**Deadline 10: *12 October 2021***

**Sizewell C (SZC)**

**EN010012**

**East Suffolk Council and Suffolk County Council Joint Local Impact Report review**

**DRAWING TITLE:**  
 TREE ROOST INSPECTION RESULTS -  
 TWO VILLAGE BYPASS  
 SHEET 3 OF 3

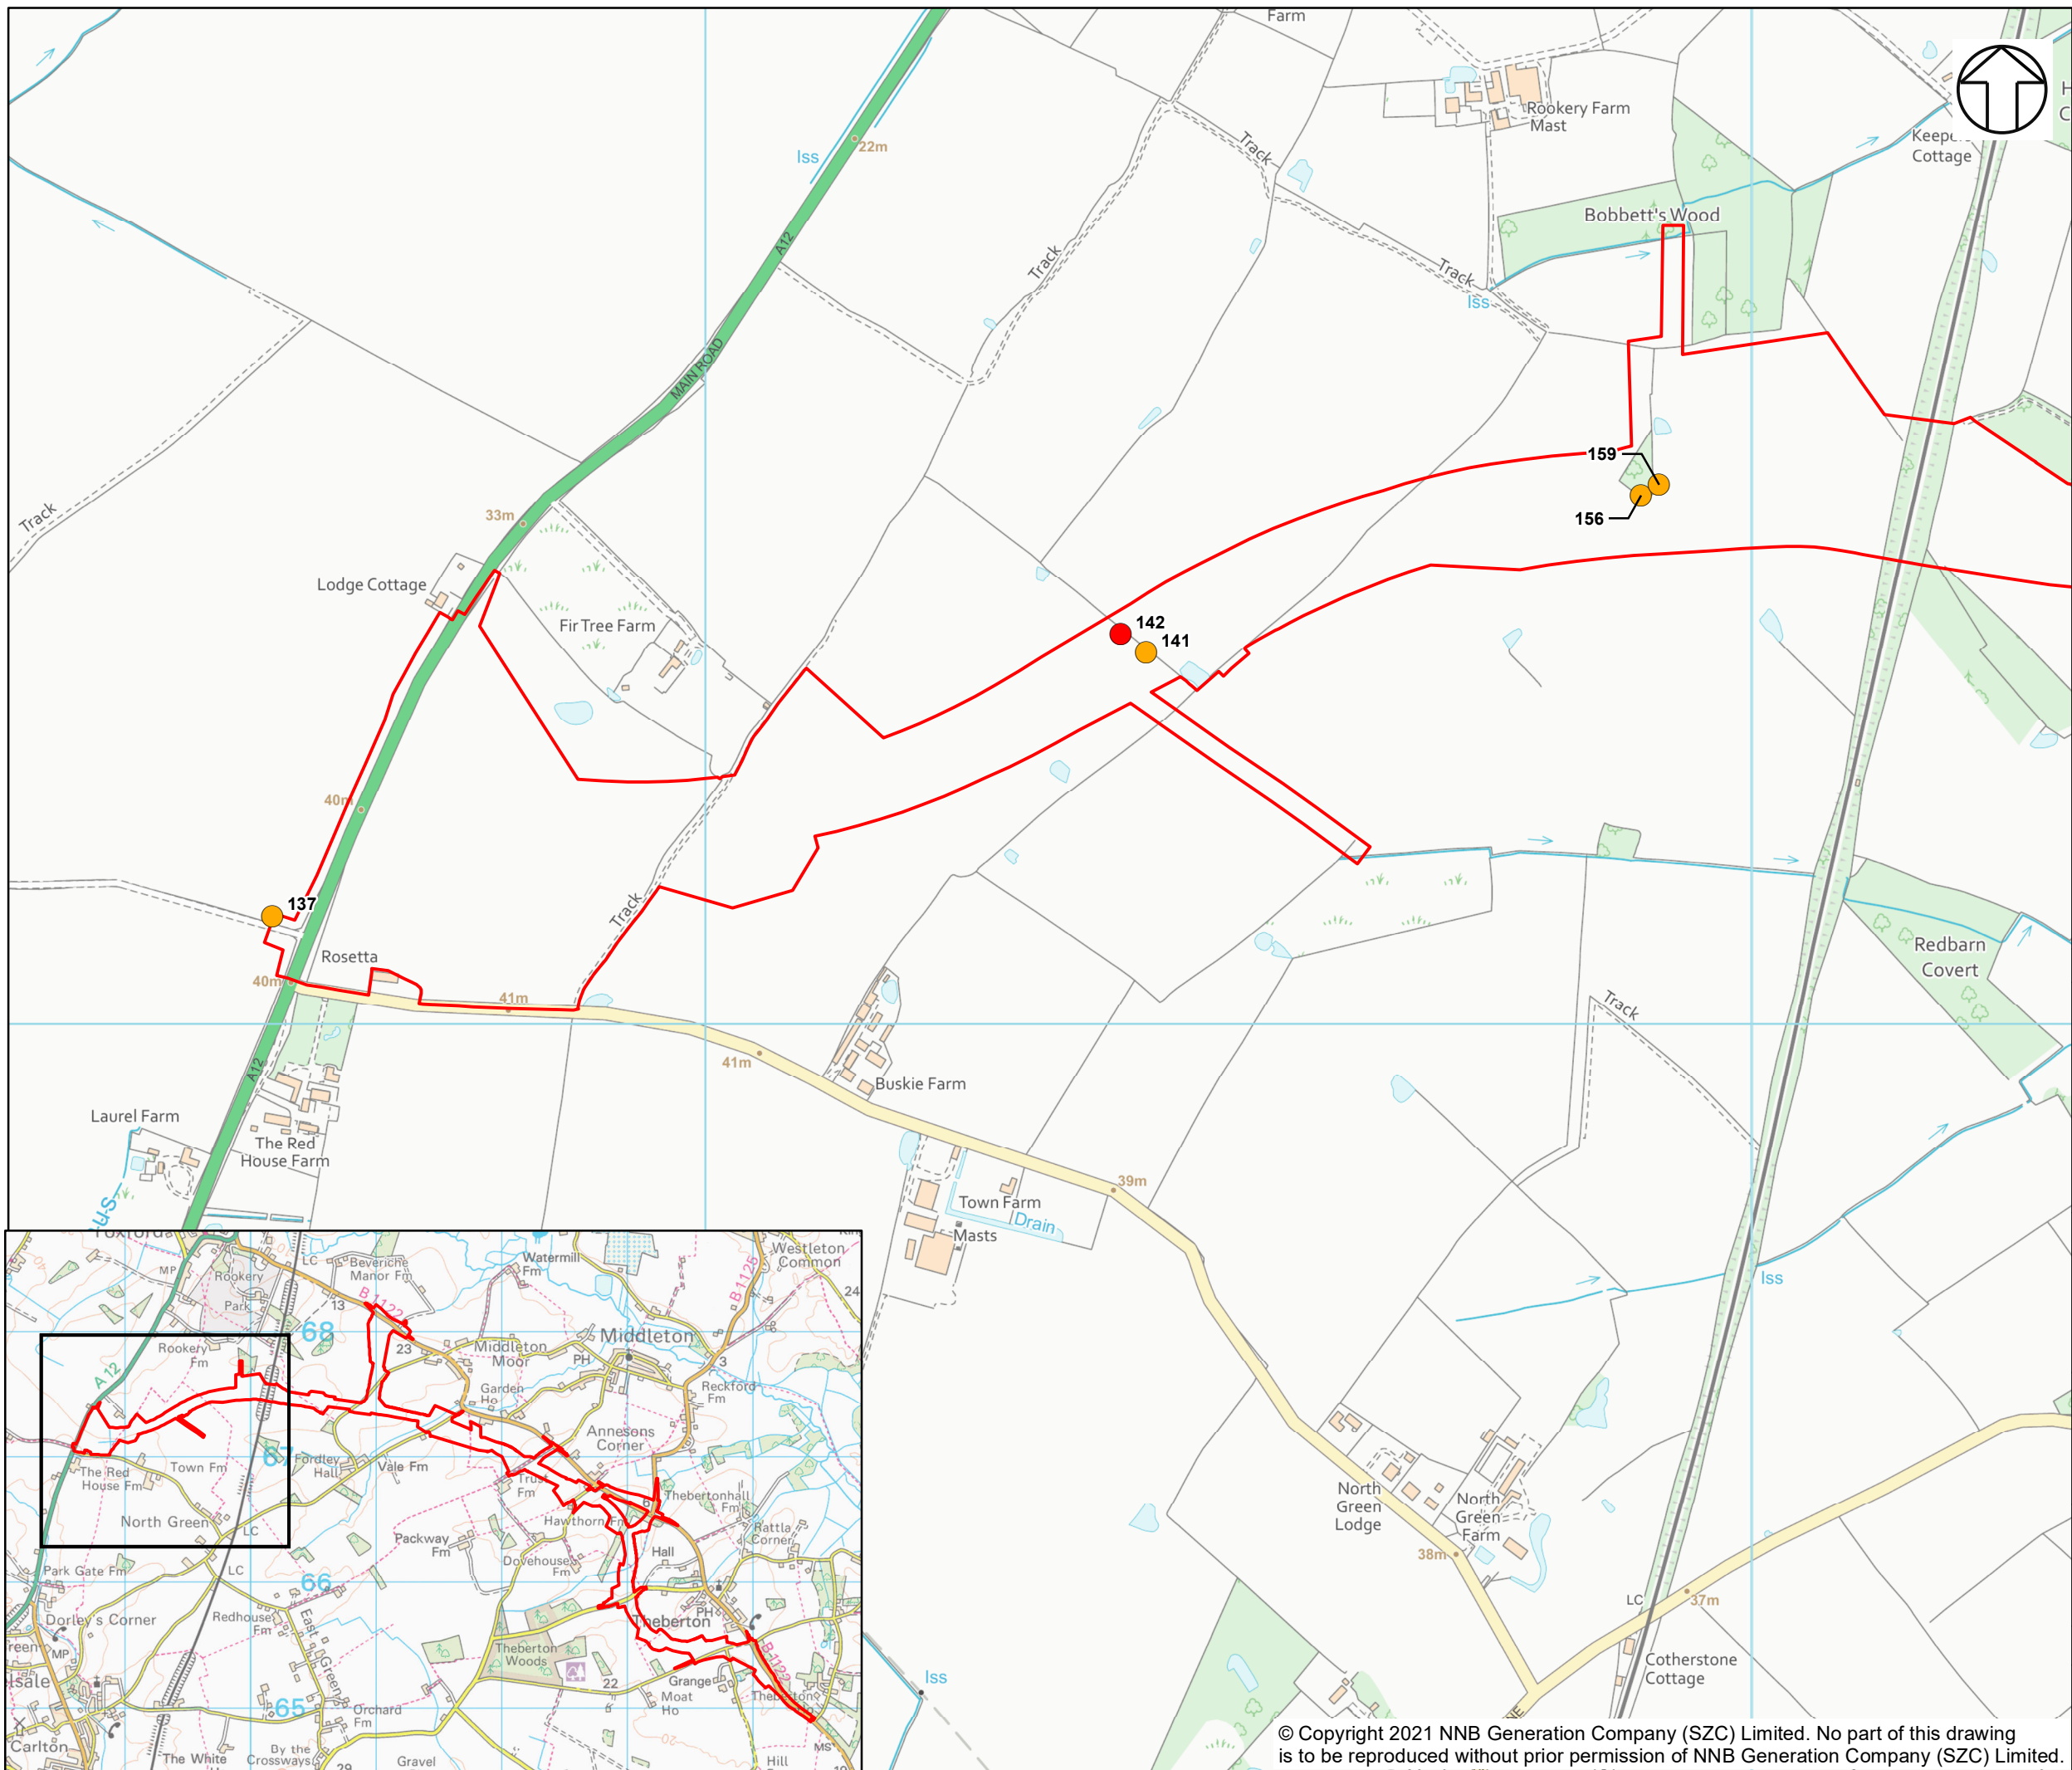
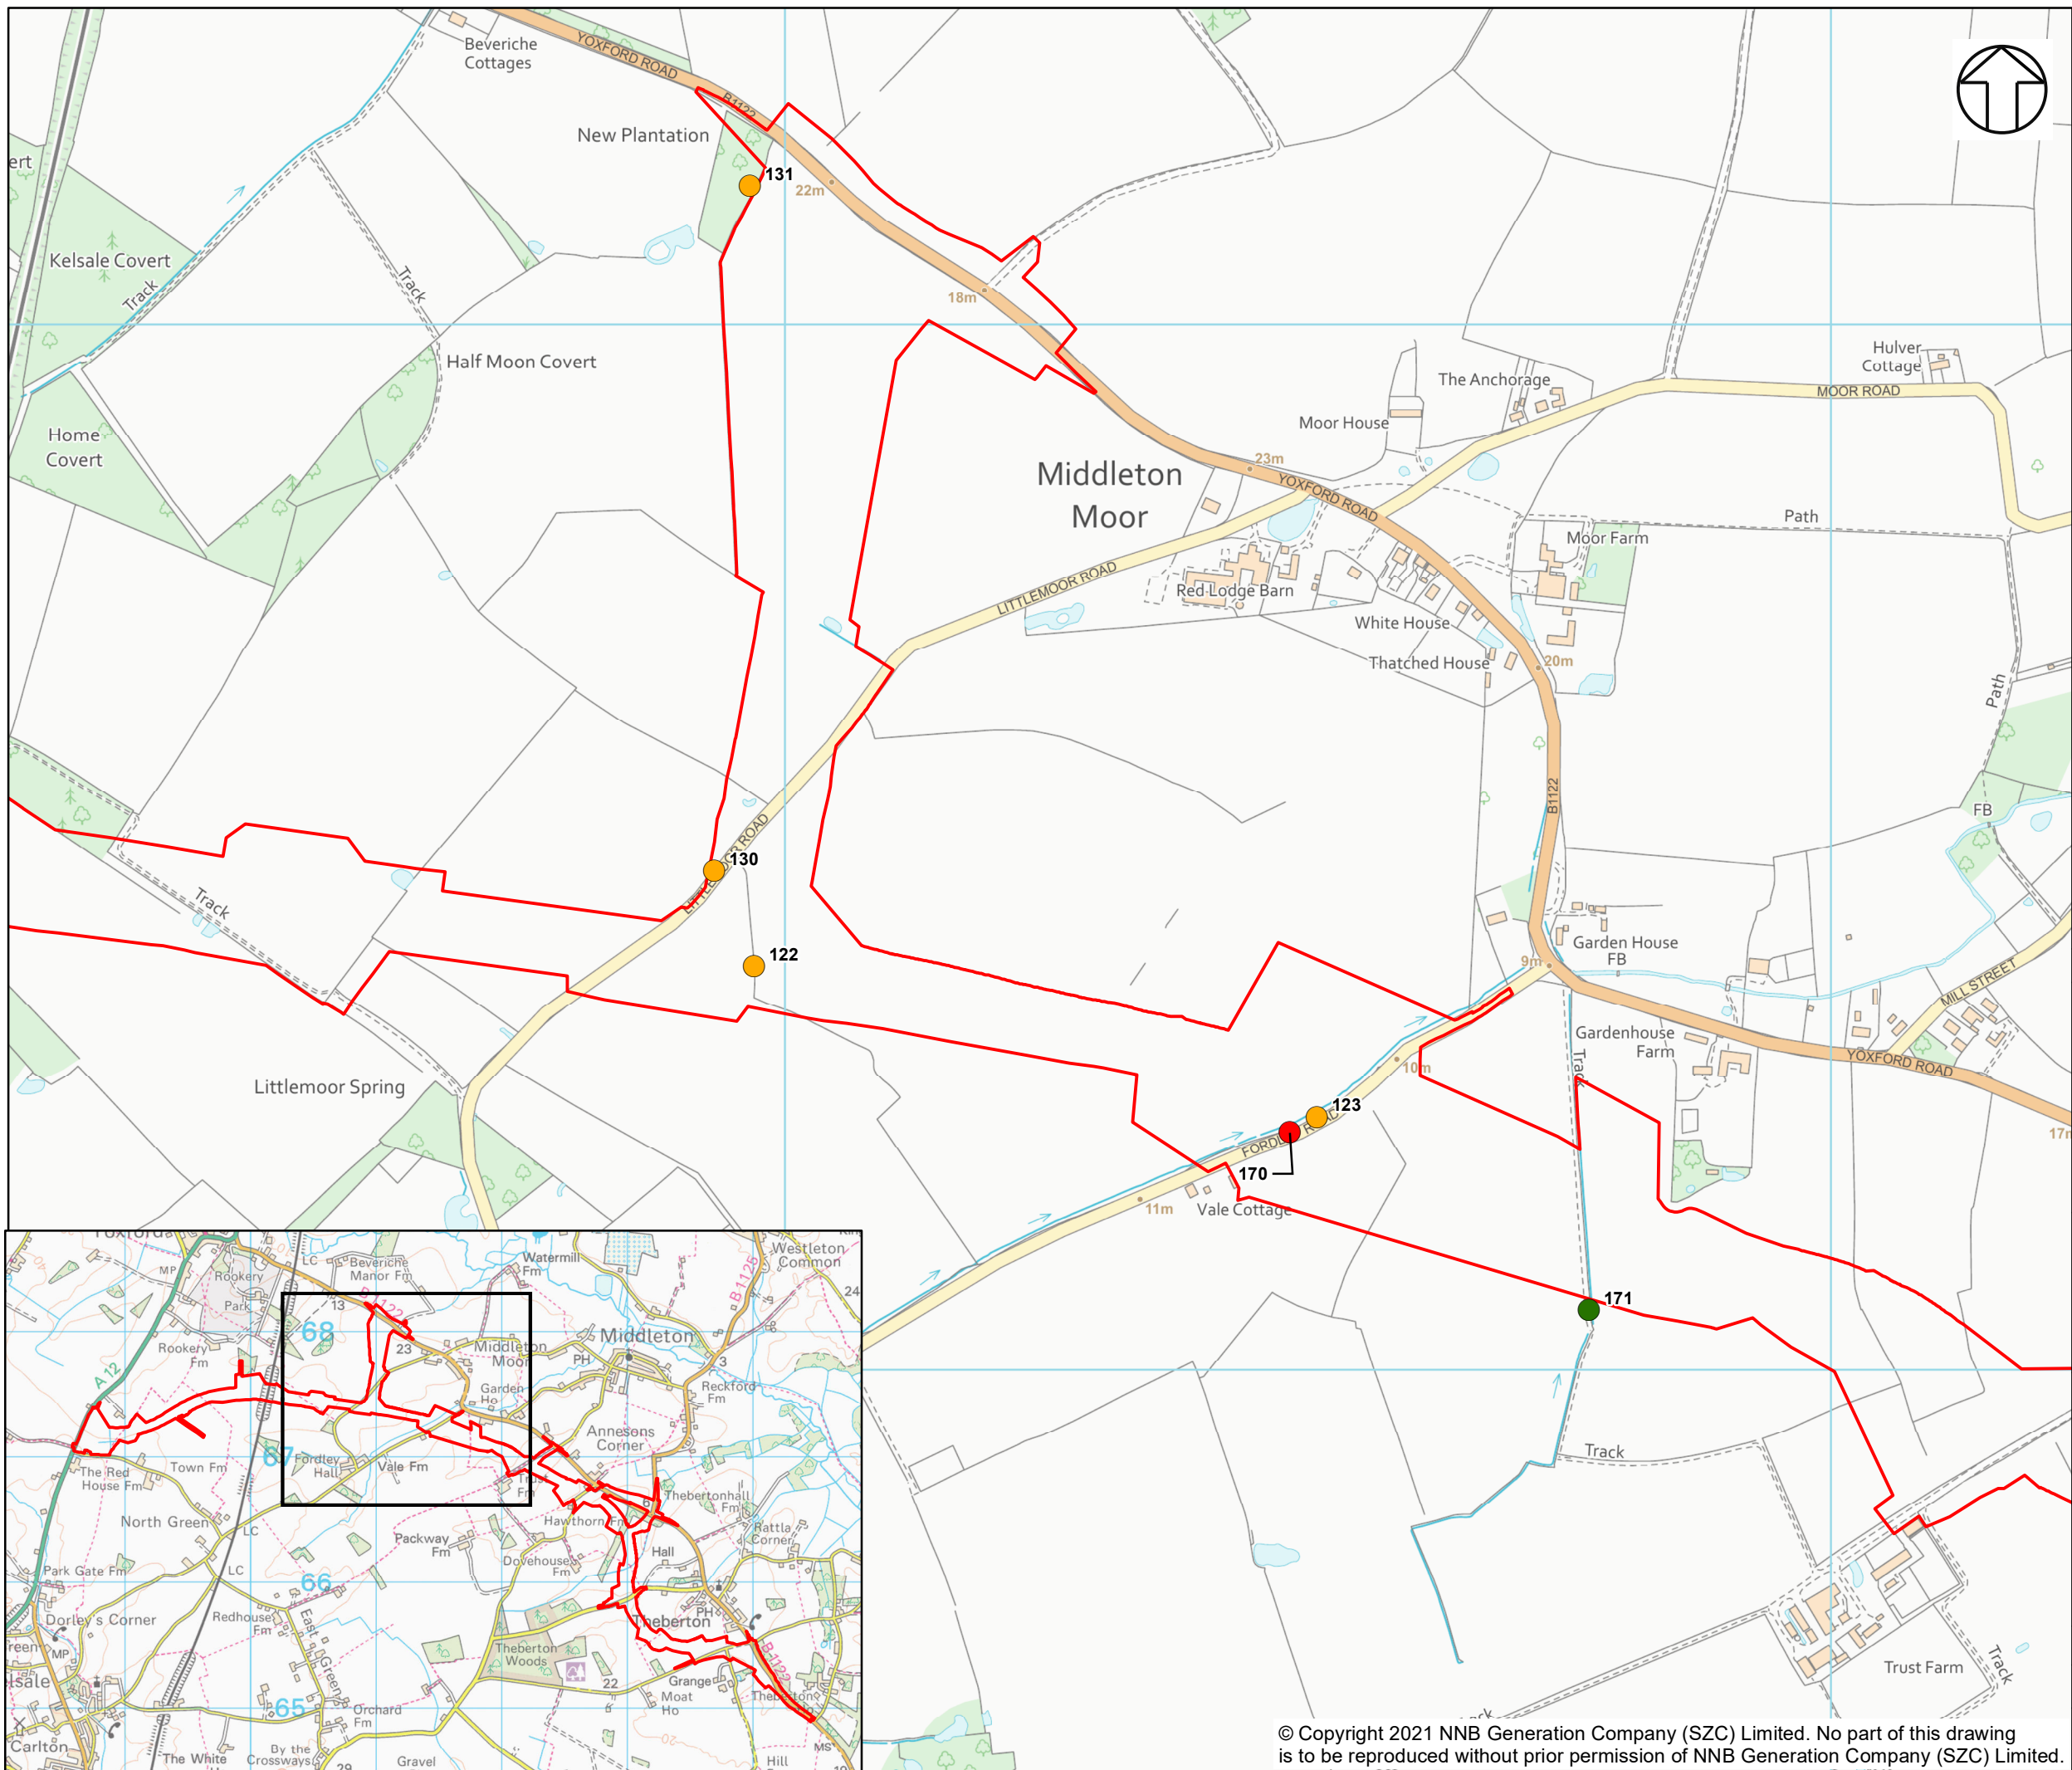
Offsite Associated Developments – Assessment Conclusions Veteran trees - Two Village bypass 8.117, 35.5	The Councils had anticipated receiving an updated report at Deadline 8 or 9 but it was not received. This point remains outstanding. The Councils are seeking a commitment to plant specimen trees to mitigate, in the long-term, for the loss of veteran trees, and this is to be included in the updated LEMPs for the Two Village Bypass and Sizewell Link Road.
Offsite Associated Developments – Mitigation - Sizewell Link Road 8.123 - 8.124	The Councils are satisfied with the LEMP, subject to the amendments that the Applicant has agreed to make in the version submitted at Deadline 10.
Offsite Associated Developments – Mitigation - Two Village Bypass 8.111 - 8.112	The Councils are satisfied with the LEMP, subject to the amendments that the Applicant has agreed to make in the version submitted at Deadline 10.
